CITY OF ALBUQUERQUE

**Re: The 14 West
Grading and Drainage Plan
Engineer's Stamp Date 1-15-2014 (K13/D050A)**

Based upon the information provided in your submittal January 15, 2014, the above referenced plan is approved for Work Order and Building Permit based on the following condition:

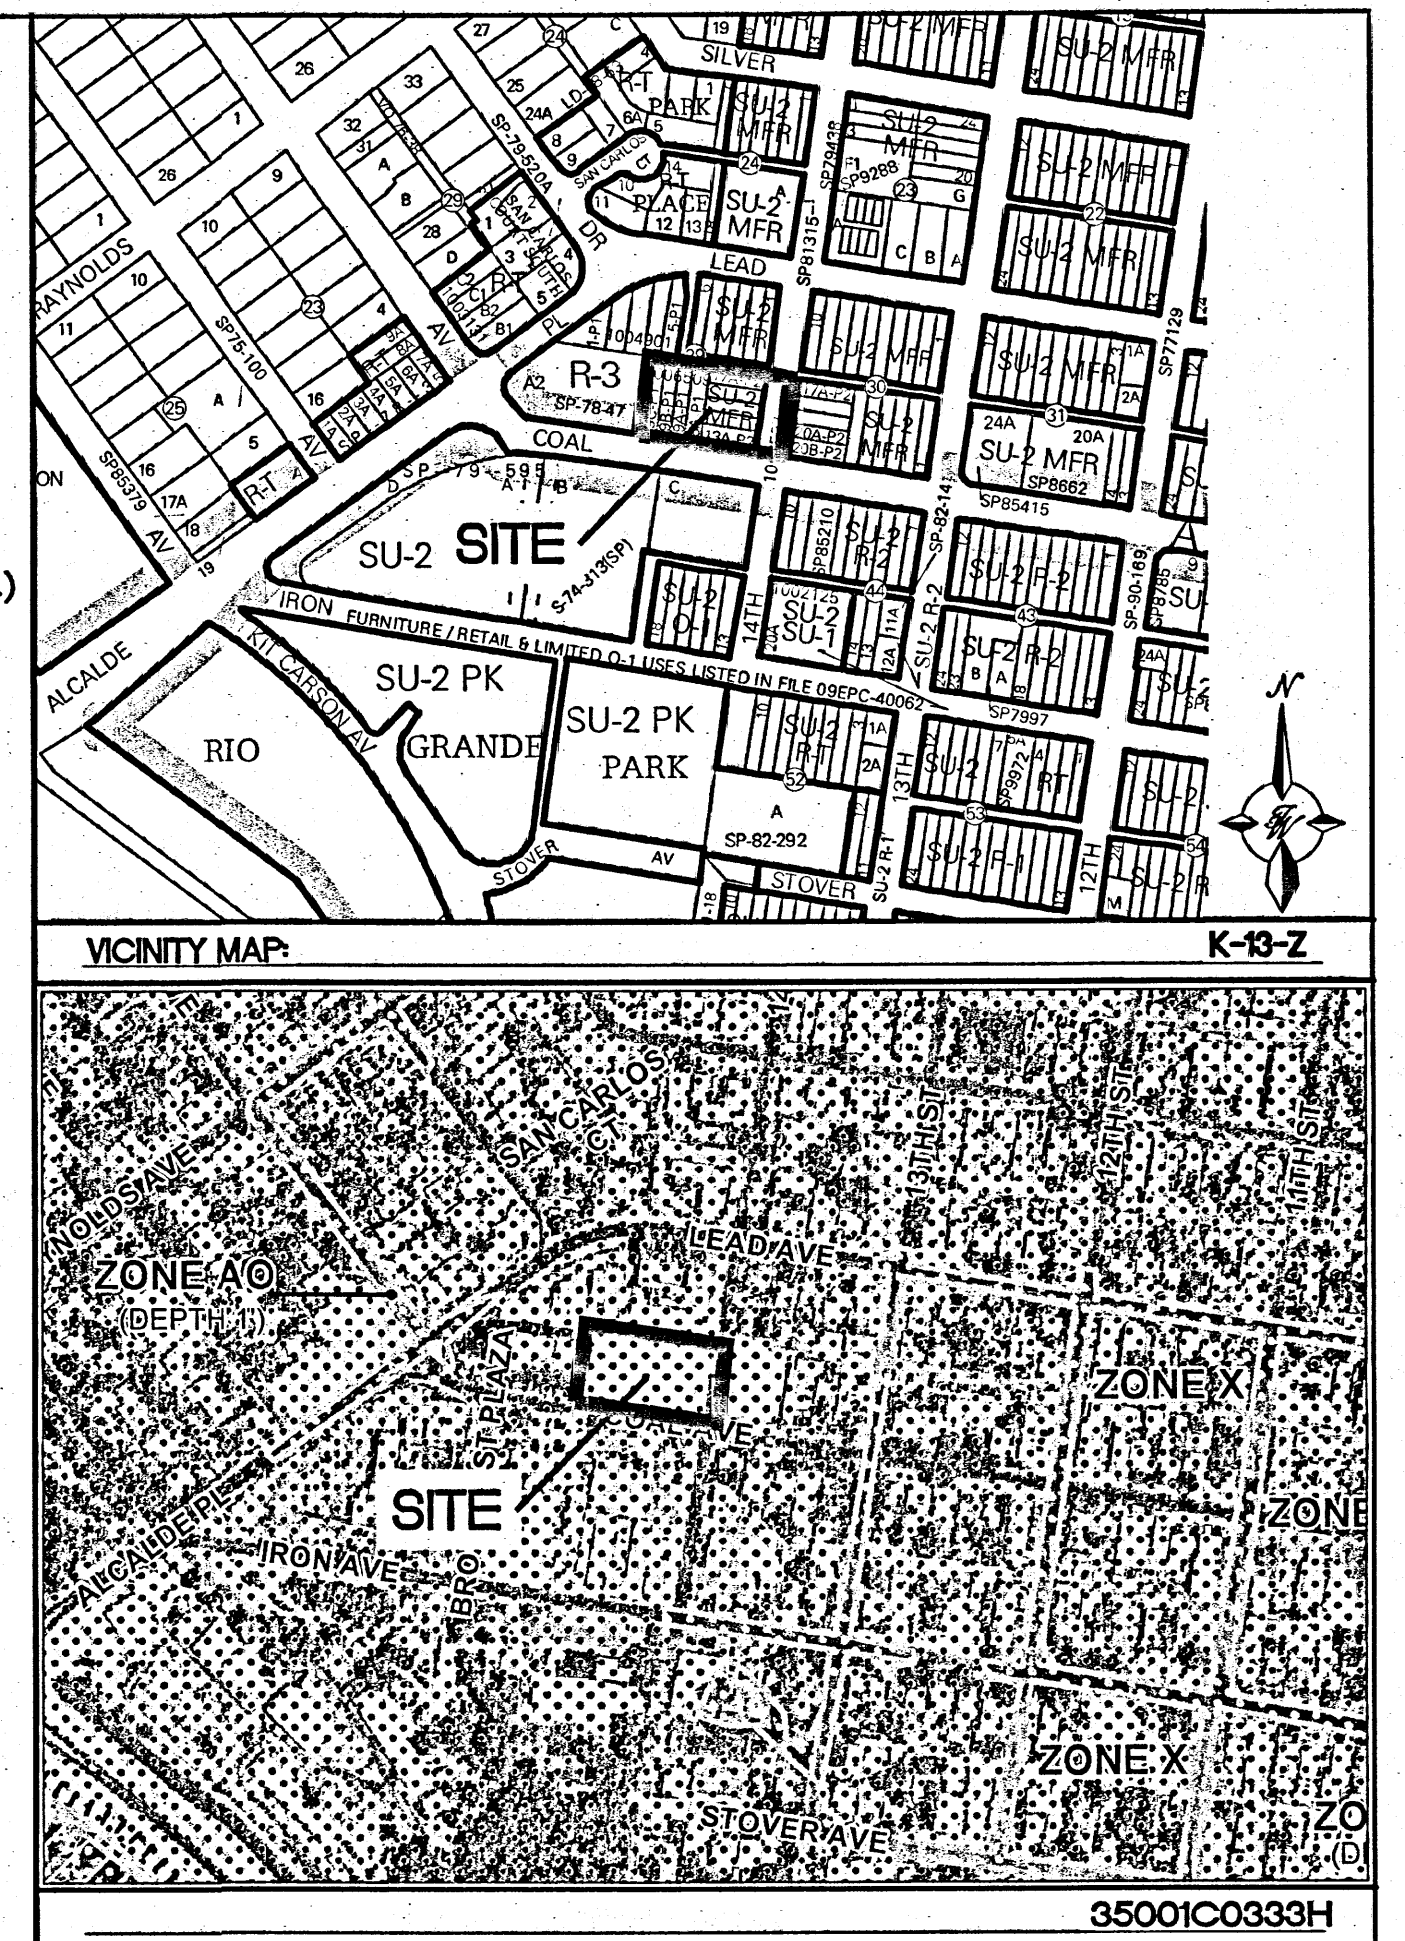
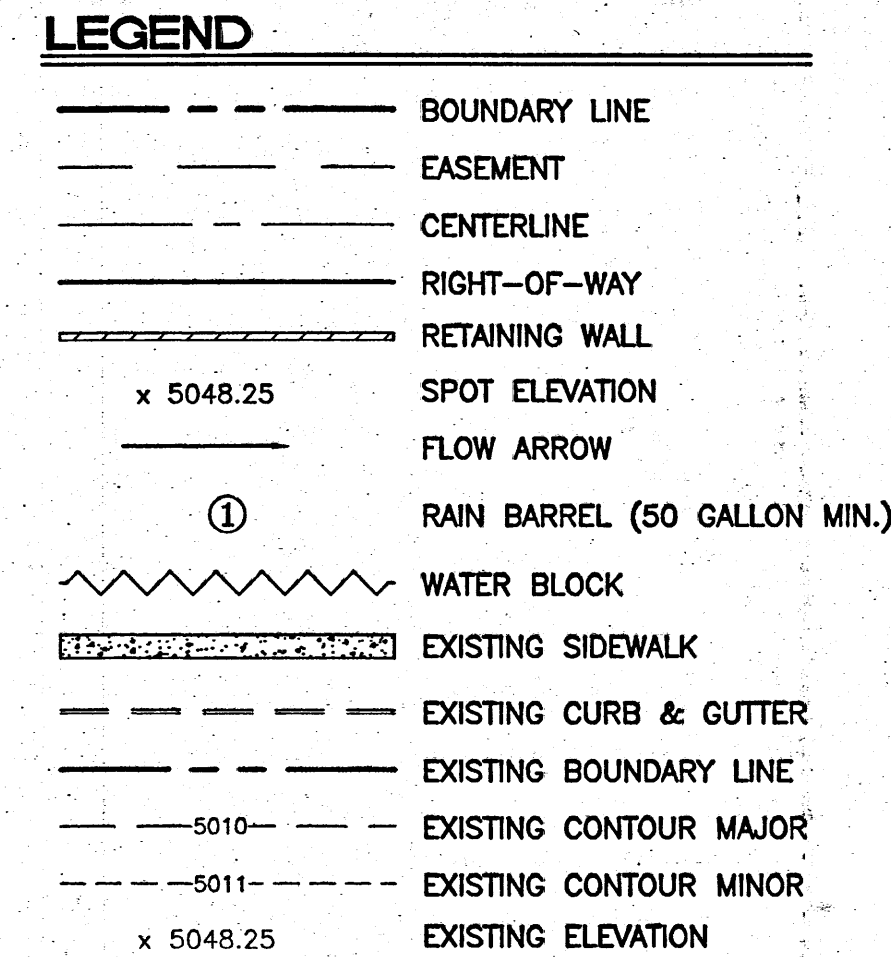
- Show more spot elevations along the alley to assure the runoff and gates/entrances are not being blocked with the proposed alley improvements. Show all the existing improvements.
